From: Dominic Smith [REDACTED]
Sent: 15 September 2014 14:05
To: Tim Rainbird
Cc: Neil Crowther; Claire Freeland; Angie Fenton; Harvey Rogers; Guy Bell
Subject: RE: Land at Oldlands Farm (ref. BE/73/14/PL) - Construction Management Plan (Enabling Works)

Thanks – I've spoken with the WSCC BRRR Project Manager and we're satisfied with the proposals. No objection to the discharge of the CMP for enabling works condition.

FLOOD COMPENSATION VOLUMES FOR ACCESS ROAD:

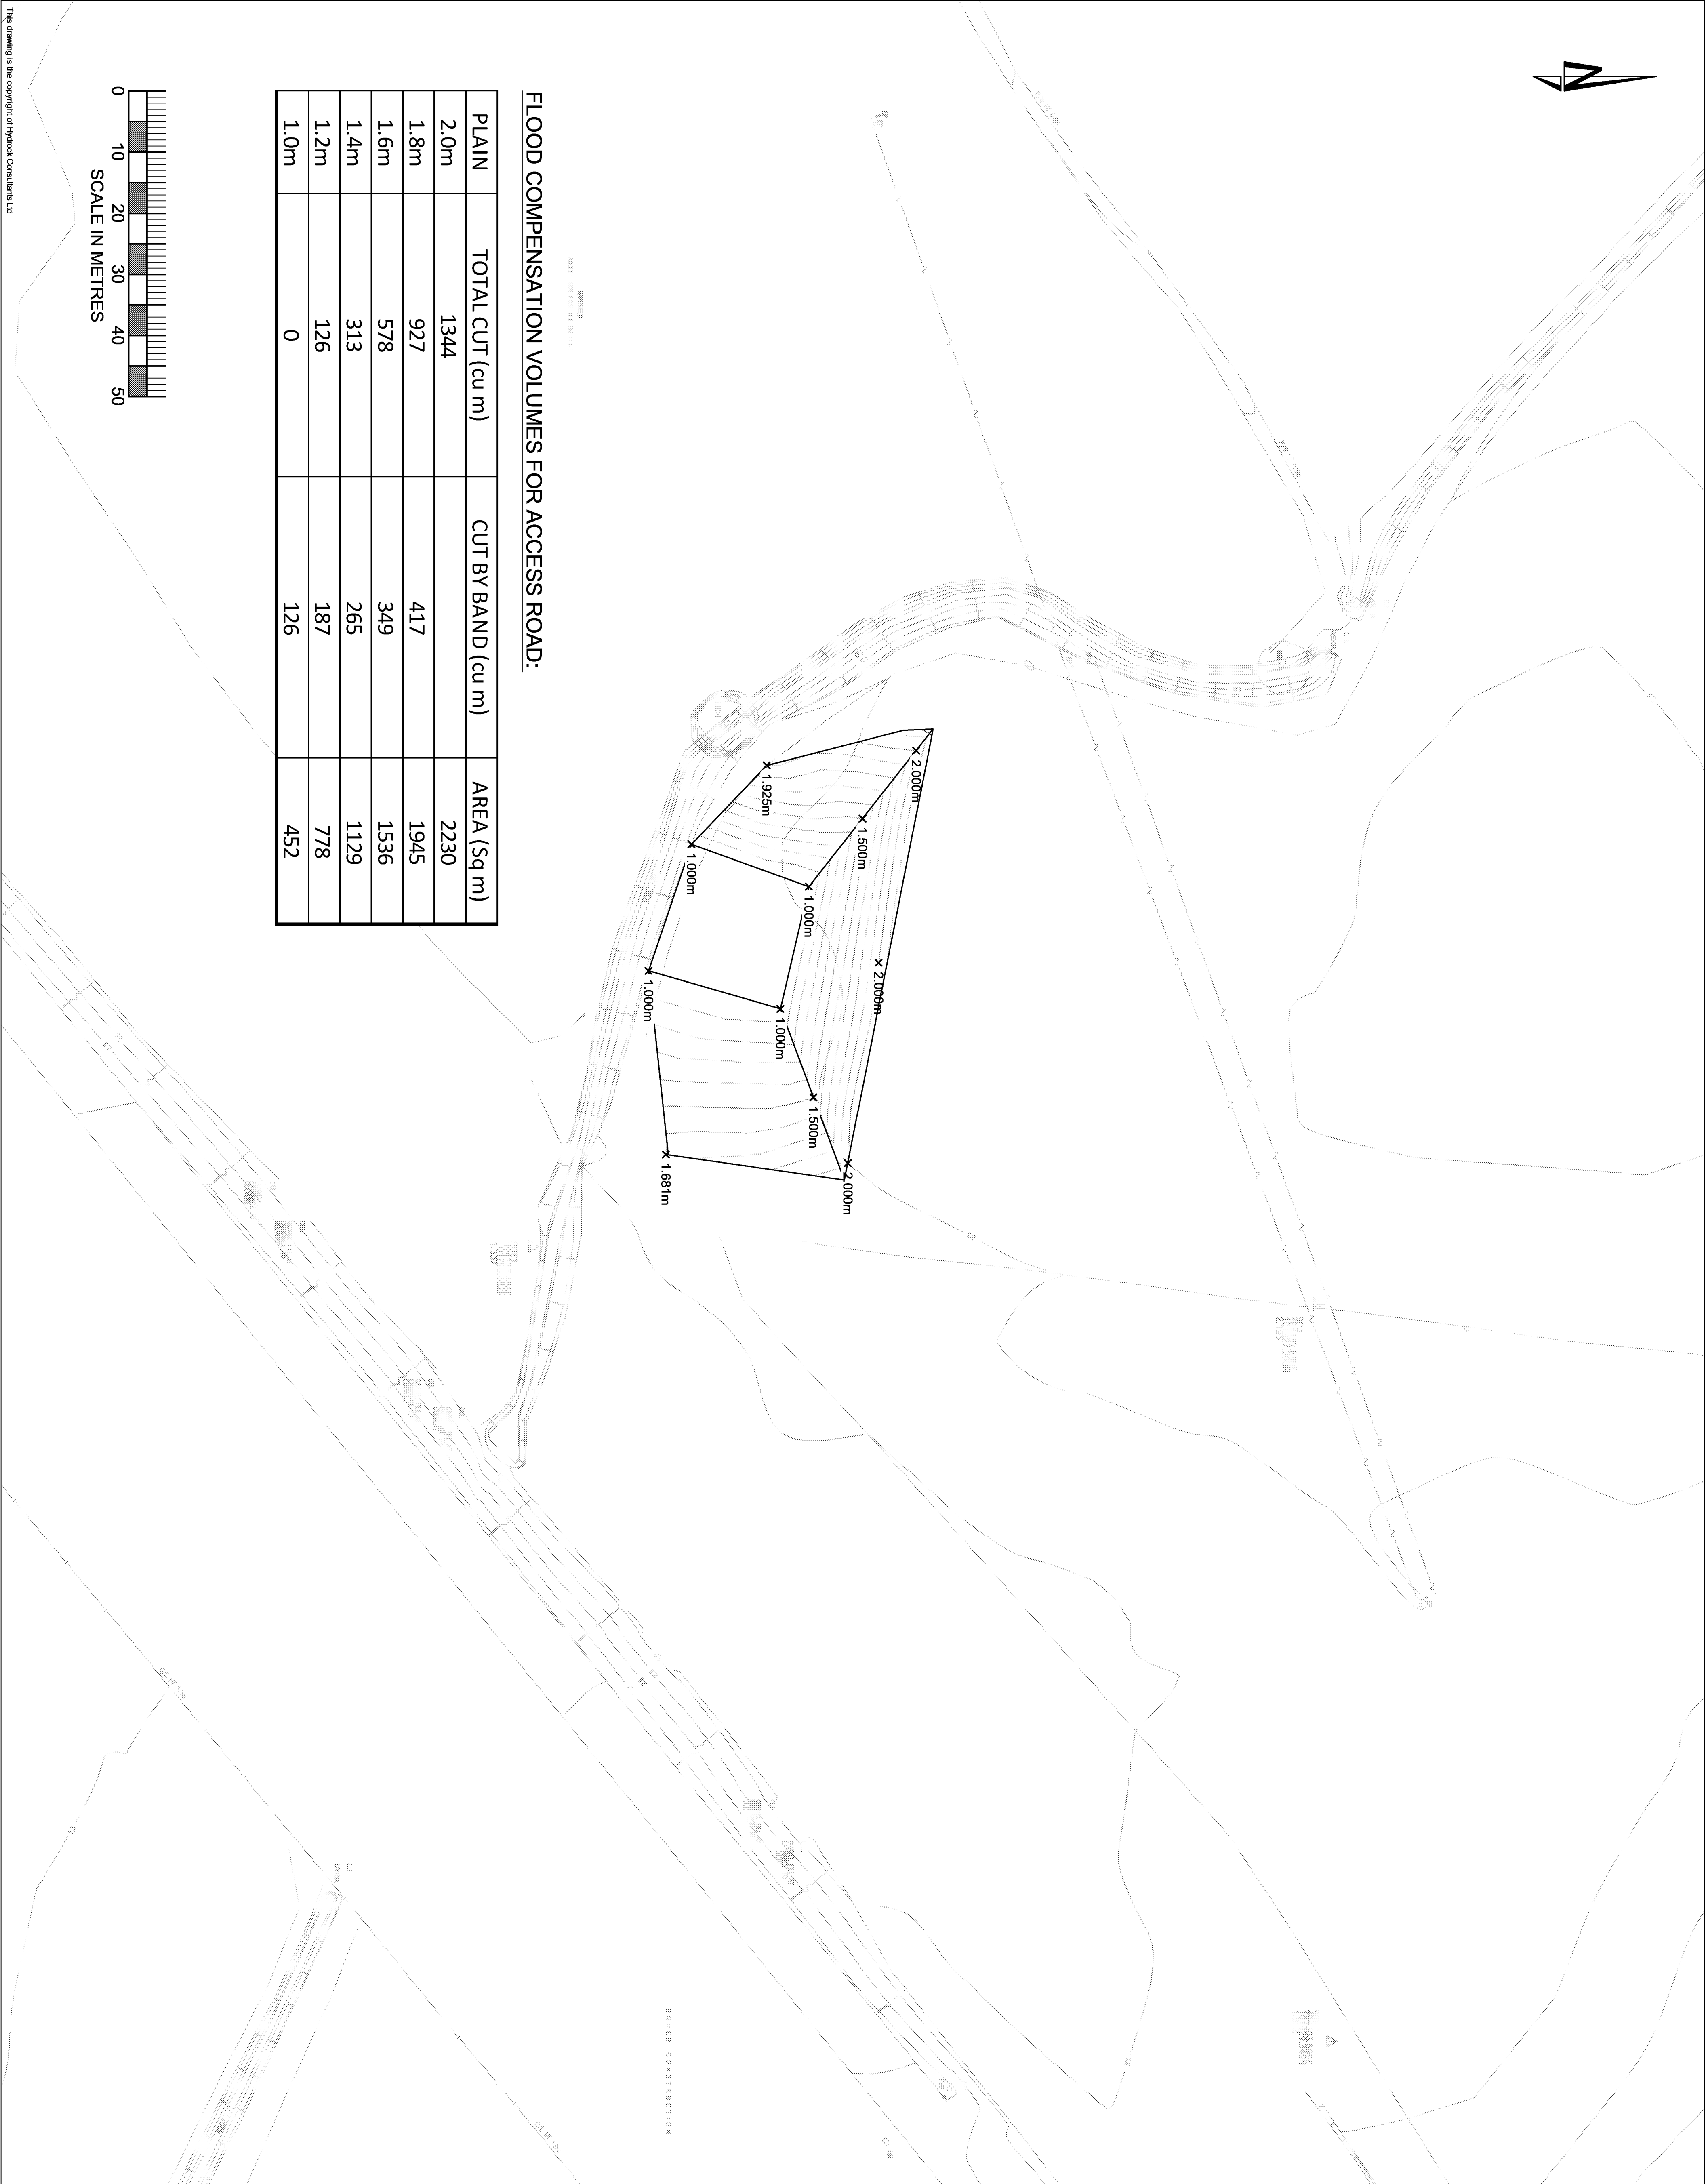
The plans don't have sufficient detail to establish, but will the haul routes cross the 5 large culverts? We have a commitment to ensure the opening of the road in 9 months, whereas any damage to the culverts could result in a substantial delay due to the specialist construction processes associated with them. If it does cross, or is in close proximity to them, what measures are in place to protect the structures?

Thank you for the revised version. Following our phone call Wednesday I understand that the intention for vehicles moving between the development and FCA sites will be to cross the Relief Road (RR) that is under construction. However, I was unable to locate the haul route plan you referred to in our discussion (this doesn't appear as an appendix to the CMP you attached nor could I find a copy on the planning website).

I've spoken with the WSCC Project Manager for the RR, Harvey Rogers (cc'd), I understand that while the RR will be subject to a S38 that it is still technically under private ownership at this stage. Has permission been sought from Barratt's to cross the construction, are there plans of the crossing point that take into account the height difference, culverts etc?

Secondly, no, the culverts will not be crossed.

I can also confirm that Barratt have given Bericote approval to cross the RR including agreement of protective measures.
